MDT-PUDSP21010-R1-TIS.pdf Markup Summary

Figure 2b
Intersection Spacing
 Grandview Reserve Phase 1 (LSC #S214240)

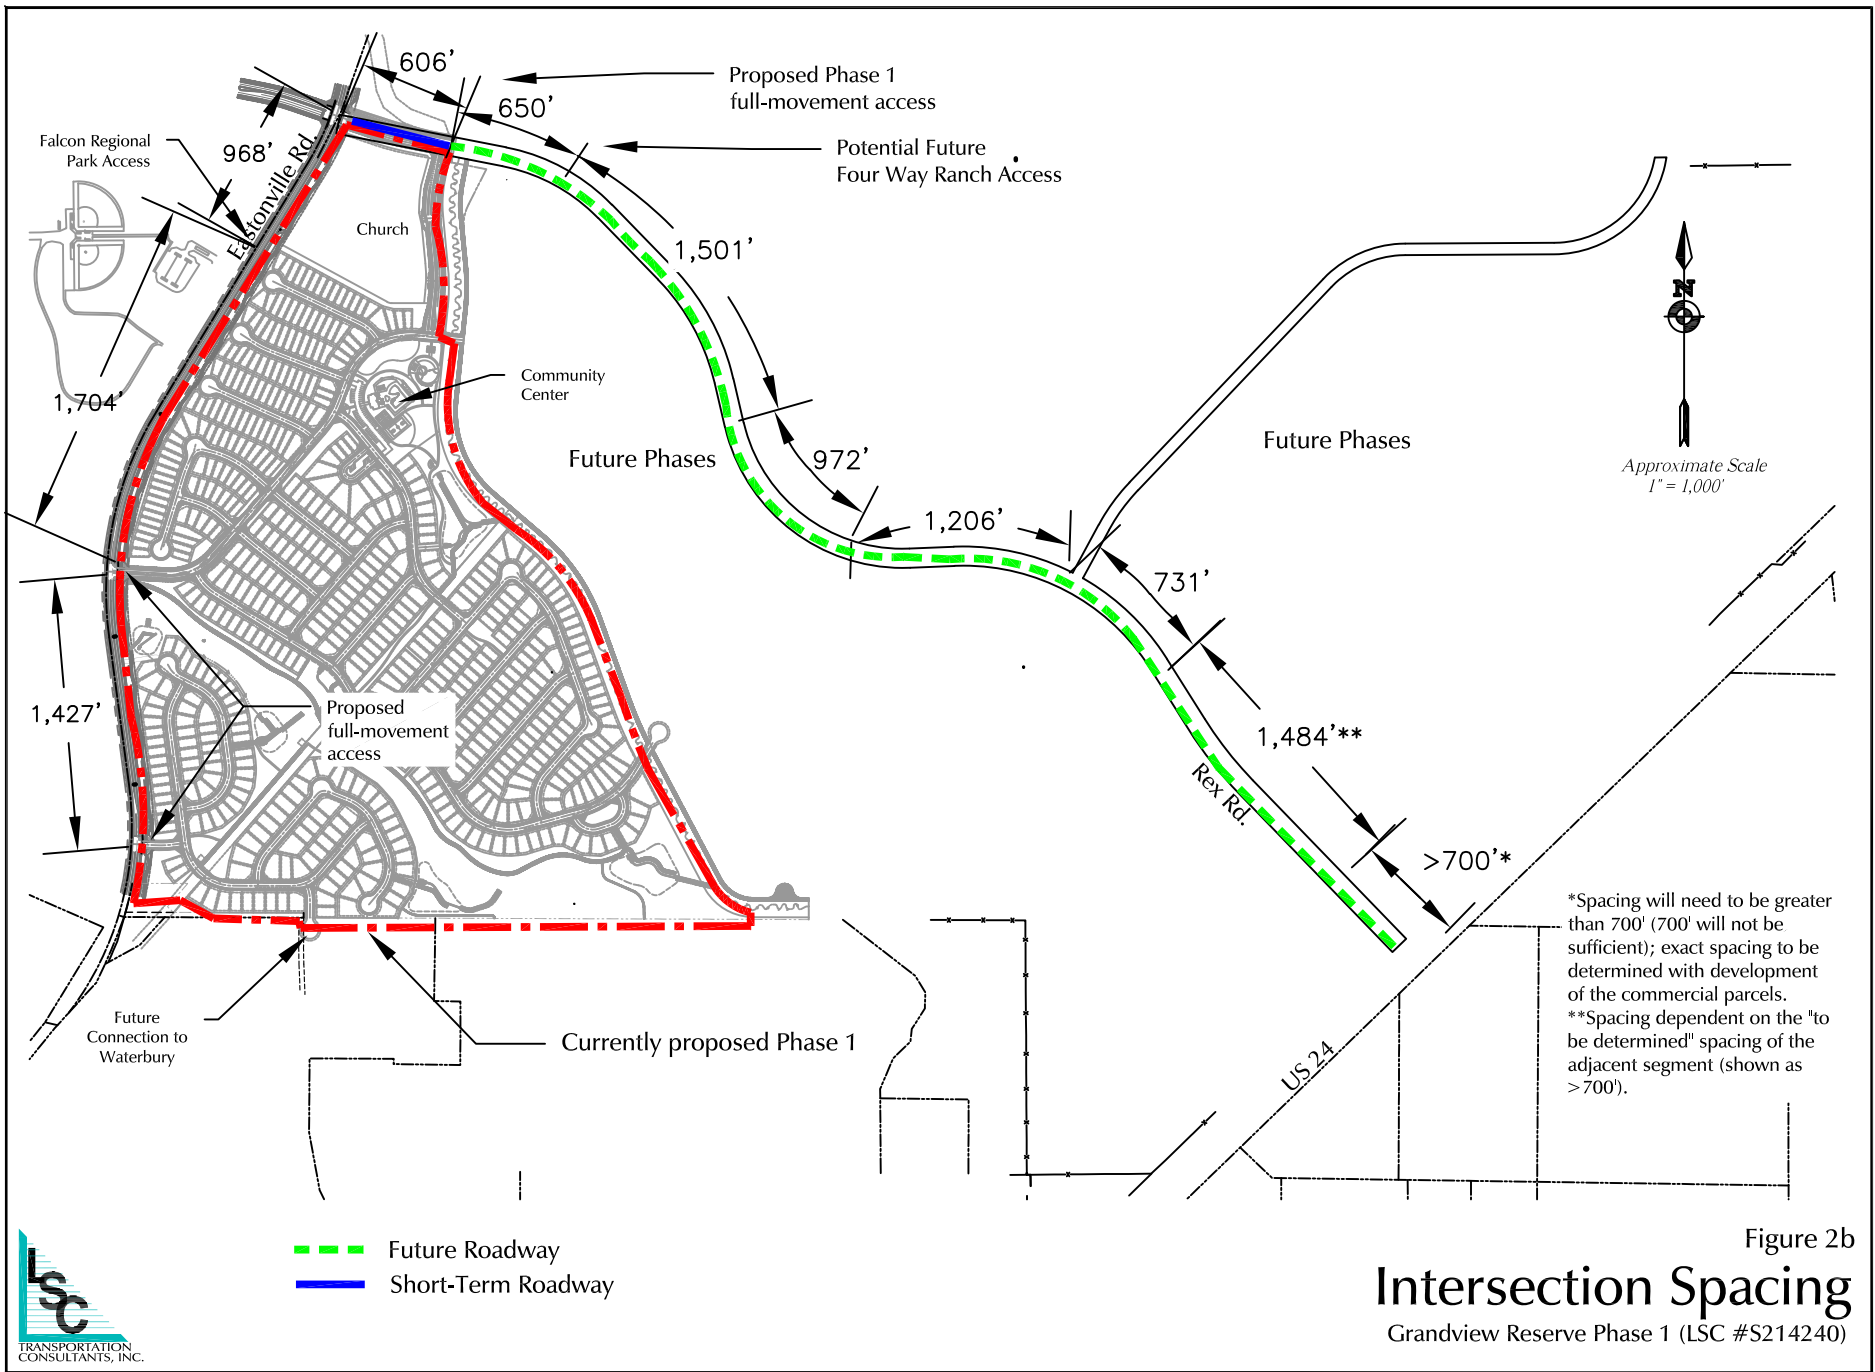
This needs to be >700'

650' (minimum) will be acceptable

Figure 13

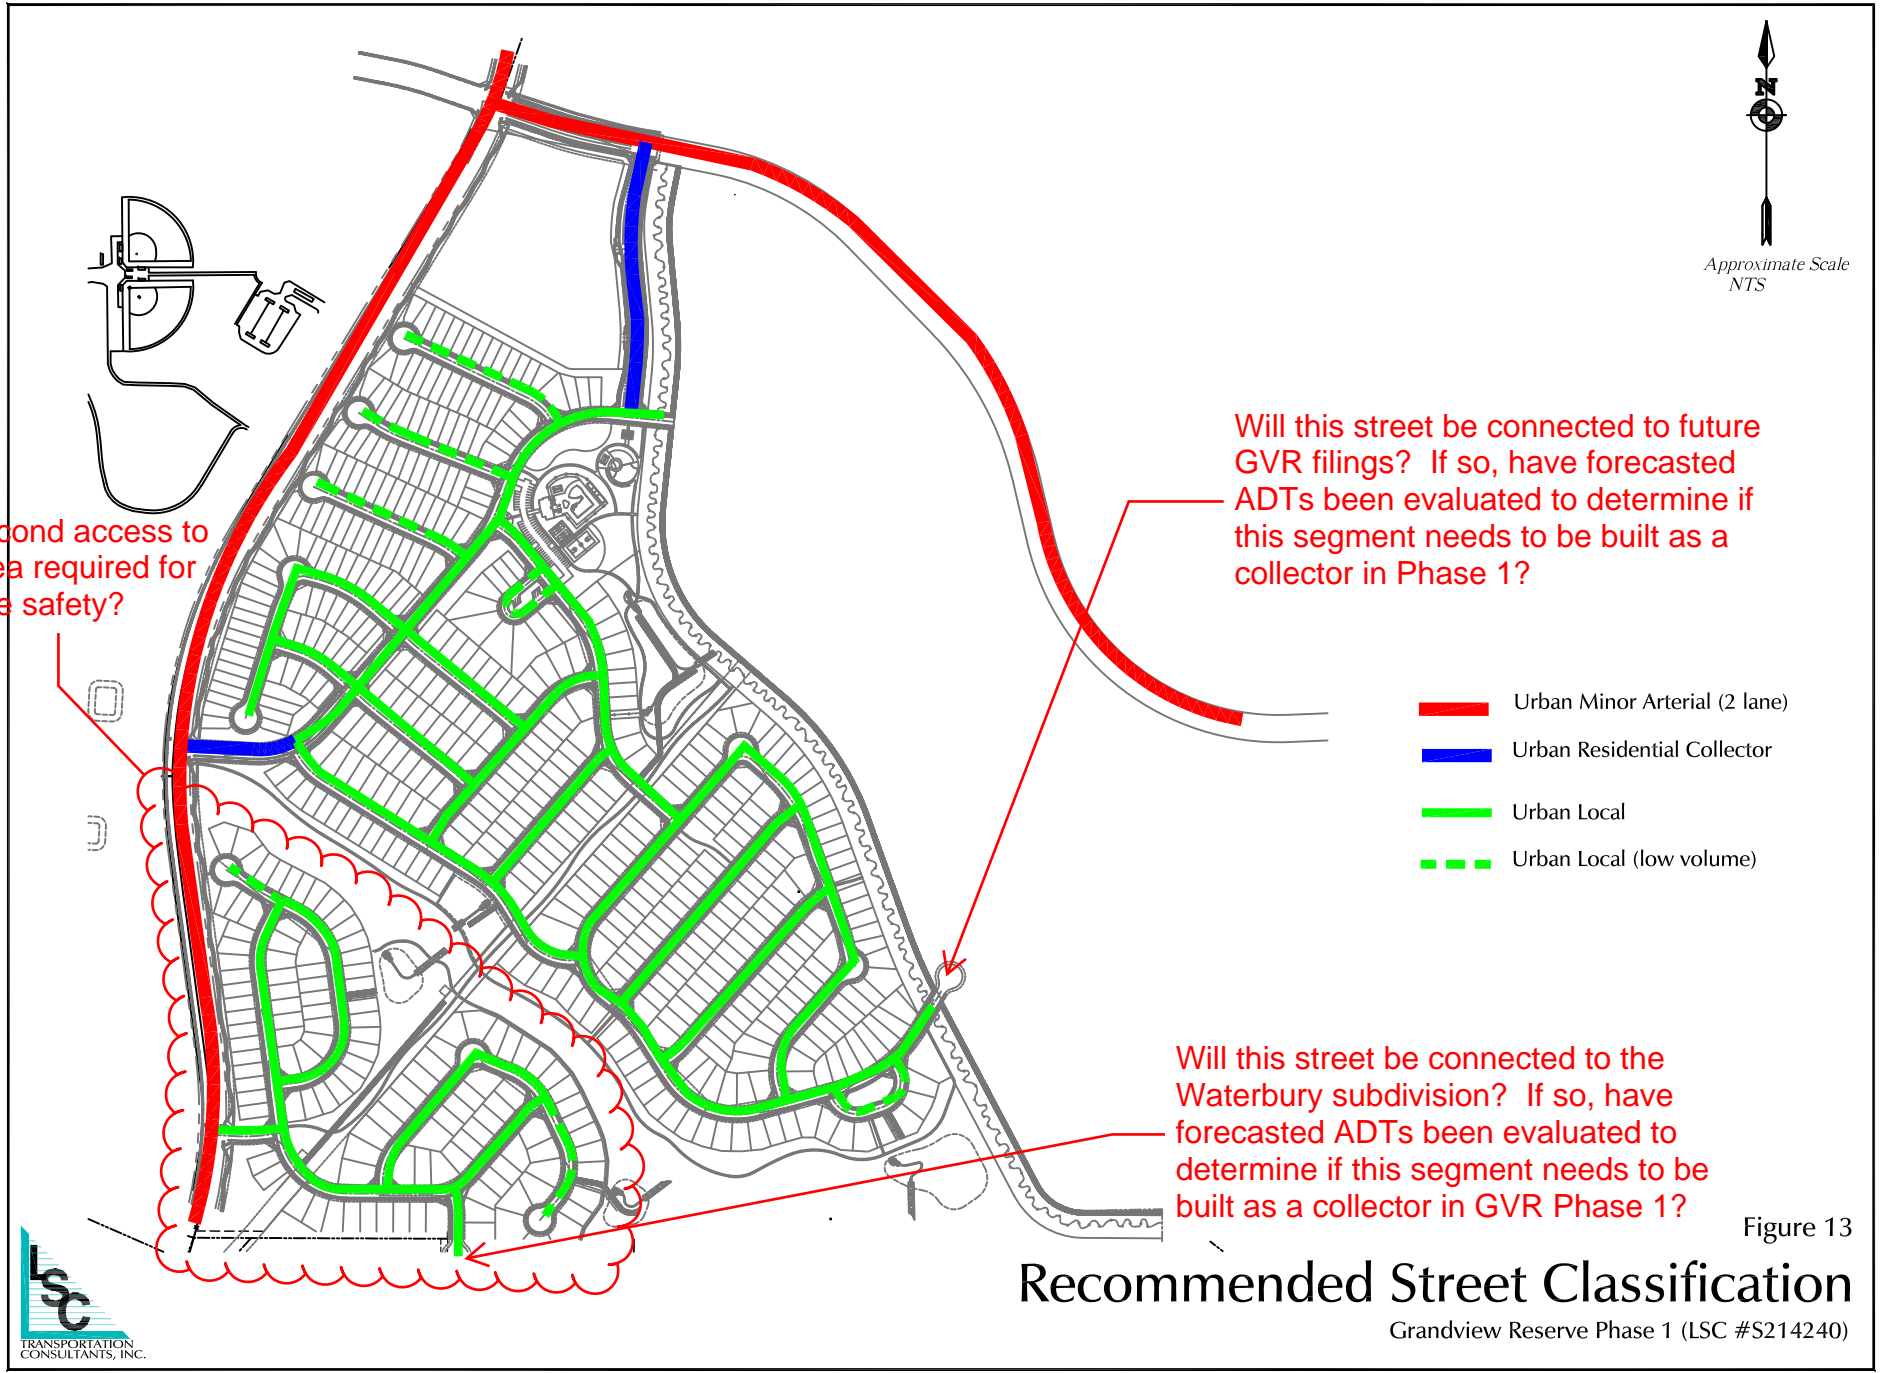
Verify that this will not need to be a collector with the other uses added
